**Our ref:** NE/2022/135016/02-L01  
**Your ref:** 6/2022/2300/COND  
**Date:** 12 January 2023

### **Beadles Volkswagen Van Centre Harpsfield Broadway Hatfield AL10 9TF**

**Submission of details pursuant to condition numbers - 1 (construction management plan), 5 (surface water strategy), 6 (surface water scheme), 7 (drainage), 8 (foundation), 9 (design plan), 10 (accessible housing scheme), 11 (highway improvement), 12 (samples), 13 (hard landscaping), 14 (soft landscaping), 15 (hard landscaping - roof garden), 16 (external lighting), 17 (cycle store), 18 (cycle store under-croft/open air), 19 (balcony screens), 20 (energy & sustainability statement), 21 (pv cells plan), 22 (bat & bird boxes), 23 (noise compliance), 24 (noise compliance), 26 - (suds), 27 (access), 28 (ev charging points), 29 (parking), 30 (bin stores), 31 (roof gardens), on planning permission 6/2020/3222/MAJ.**

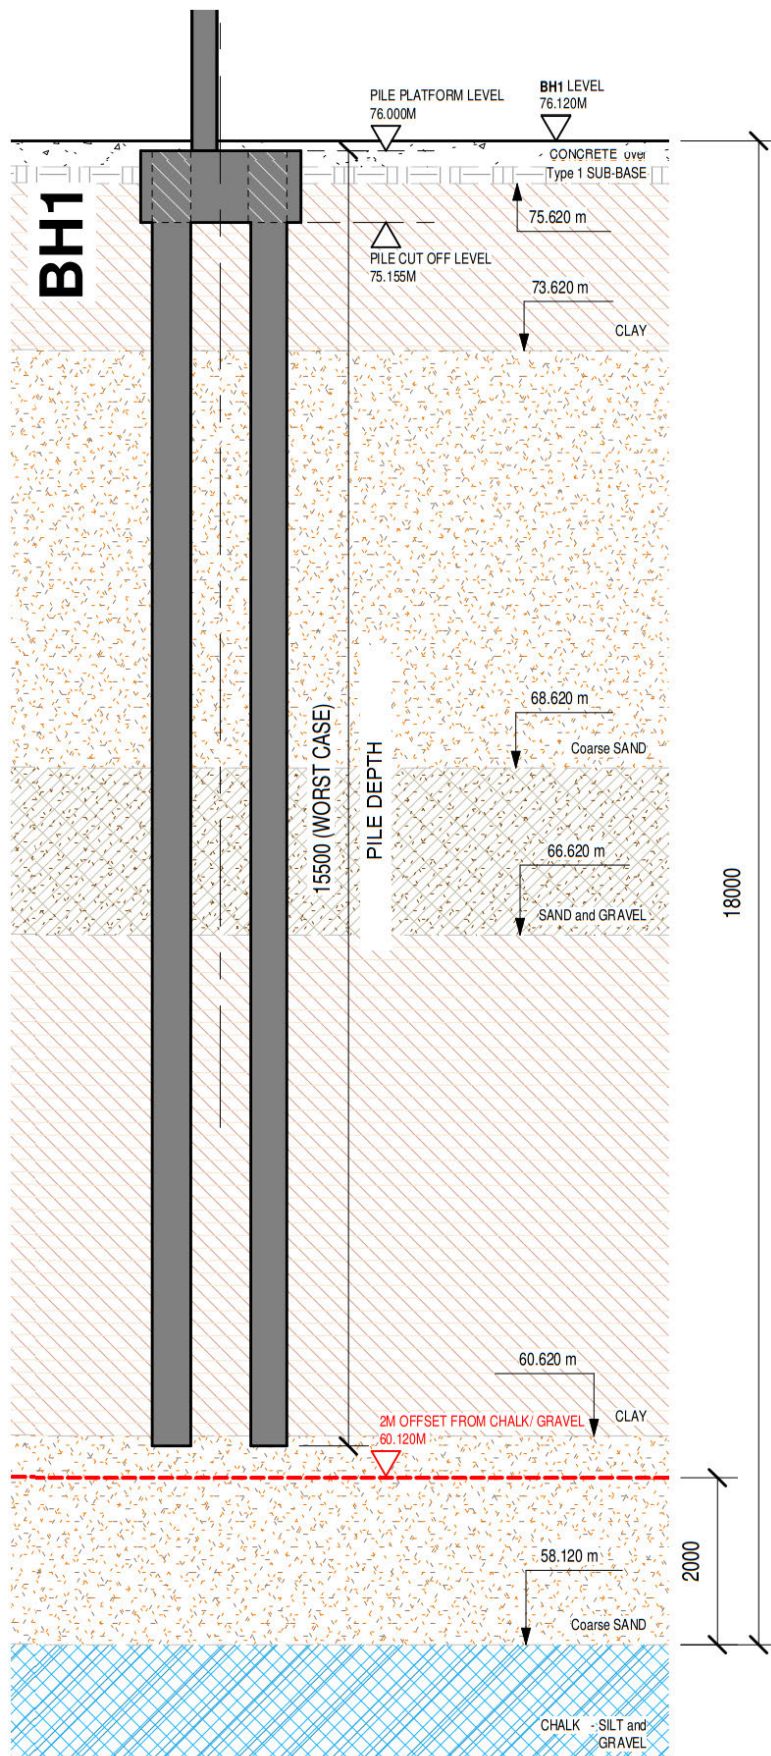
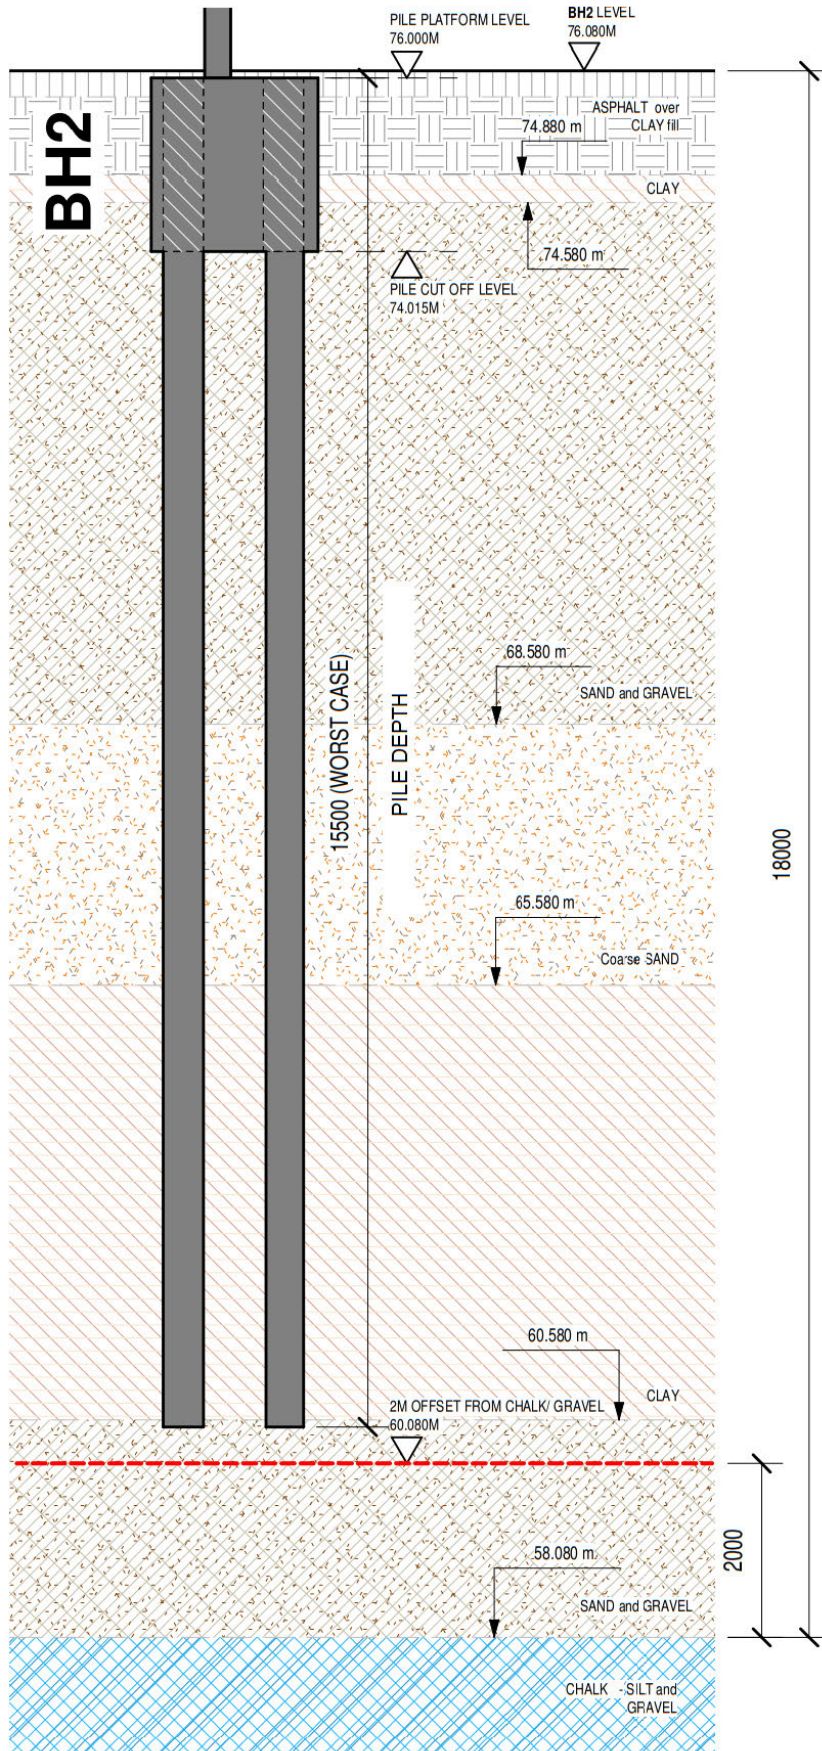
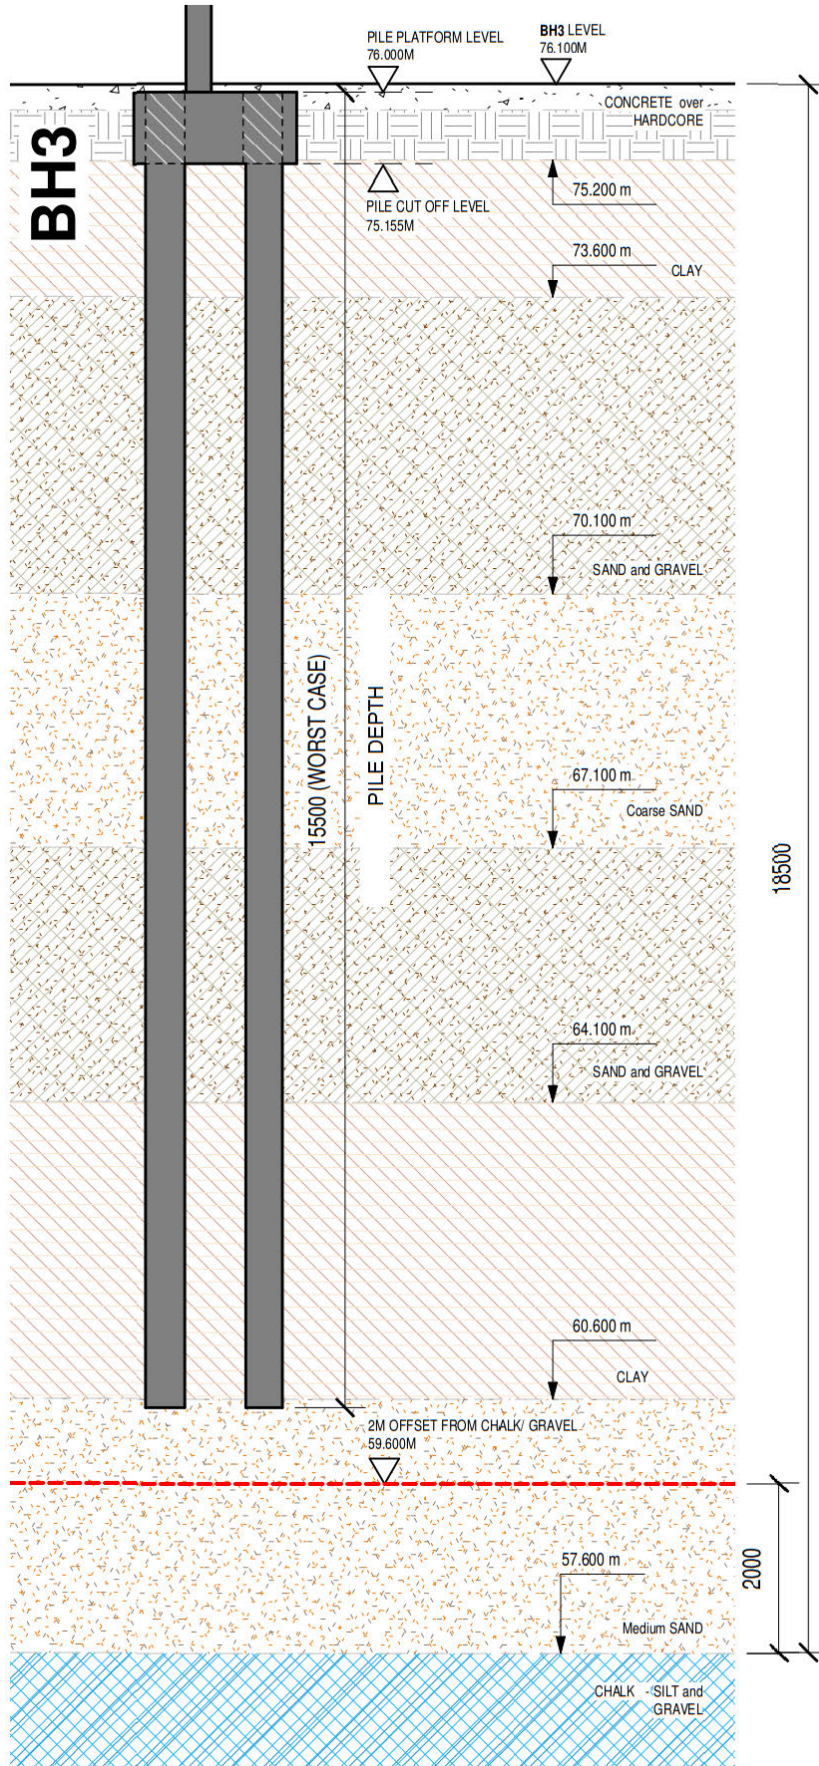
The information provided shows that the piles will likely terminate in the sand and gravel strata that immediately overlies the Chalk Groundwater. This sand and gravel strata is known to be in hydraulic continuity with the Chalk Groundwater; it is affected by the bromate and bromide pollution, and is afforded Principal Aquifer protections.

Please provide detailed information of the measures that will be implemented before, during and after piling to monitor and protect the groundwater within the sand and gravel and Chalk strata, which are hydraulically continuous.
